Subject: RE: A/180/21/DOC - Mayflower Way, Angmering - Construction Management Plan

Environmental Health. Agree to discharge of Condition 6 in respect of Construction Management Plan; Sunninghill revised Site Establishment plan, received 18th October 2021.

Construction Management Plan - Mayflower Way Angmering - August 2021

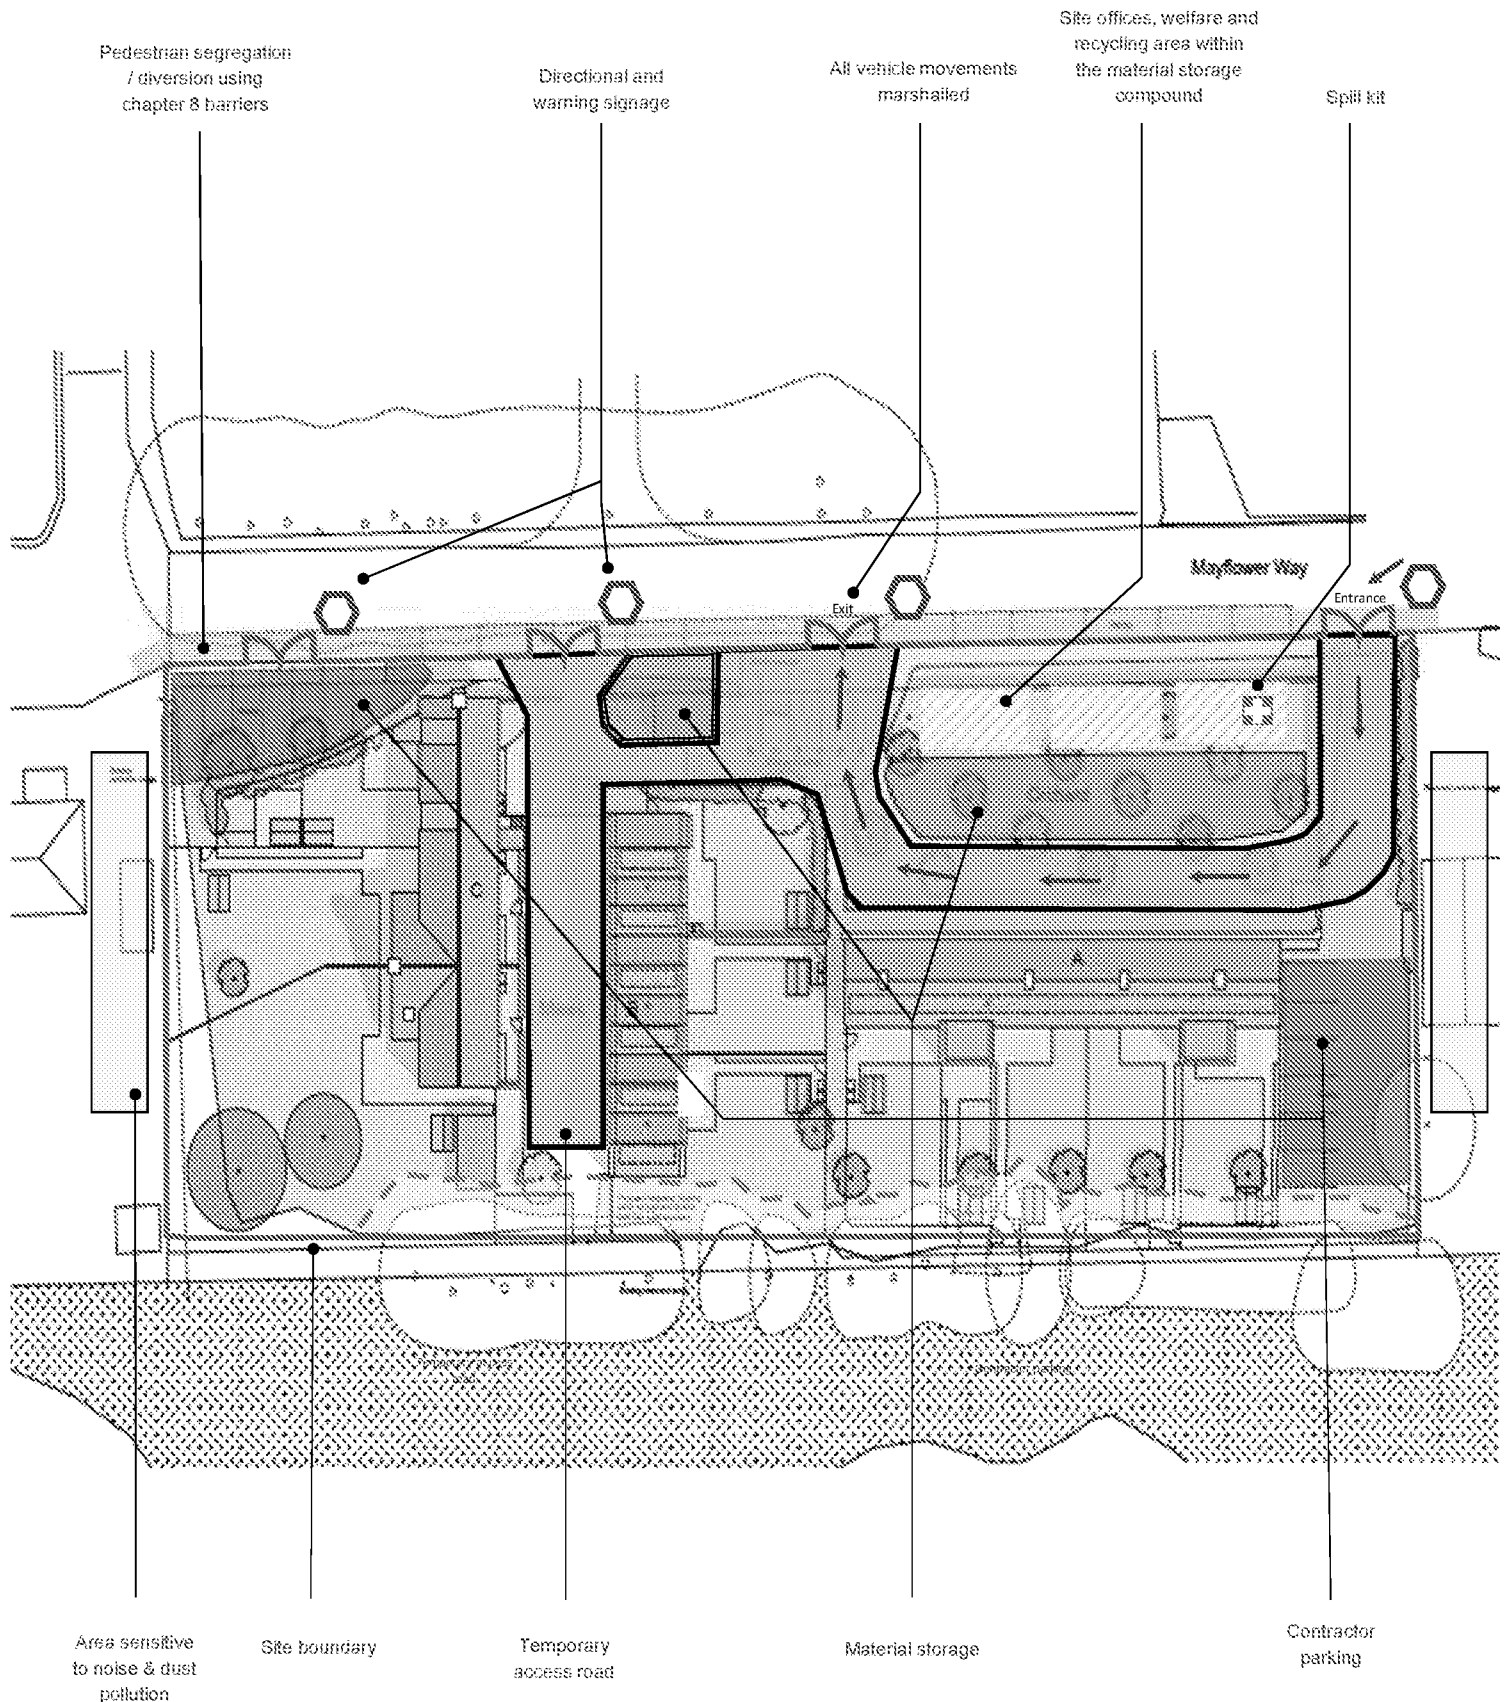
No agreement to discharge of Condition 6. The applicant will be aware of the predominantly peaceful nature of this area. It is therefore of concern to note that both access to the site materials storage area, (which will include HGV deliveries/taking away) and to contractor car parking is proposed along the boundary with a bungalow/housing to the immediate east of the proposed new housing. There is a similar, but smaller, area of contractor parking proposed immediately onto the boundary with that property to the immediate west of the site.

The location of the site access way/materials storage is therefore far from ideal and in my opinion likely to result in noise detriment/nuisance to nearby sensitive receptors. I would request for the site access way and main materials store to be repositioned to a more central position along Mayflower Way. Perhaps, it would then be possible for the main area of contractor parking to be brought forward towards Mayflower Way to form a buffer to this bungalow.

Please could the applicant describe the type of vehicles which will be included in 'contractor parking' ie will this be for vans and private cars alone/other.

Please find enclosed an updated CMP layout plan, prepared by the contractor, in response to the comments from the EHO below. We hope this addresses the concerns such as to enable discharge of this condition.
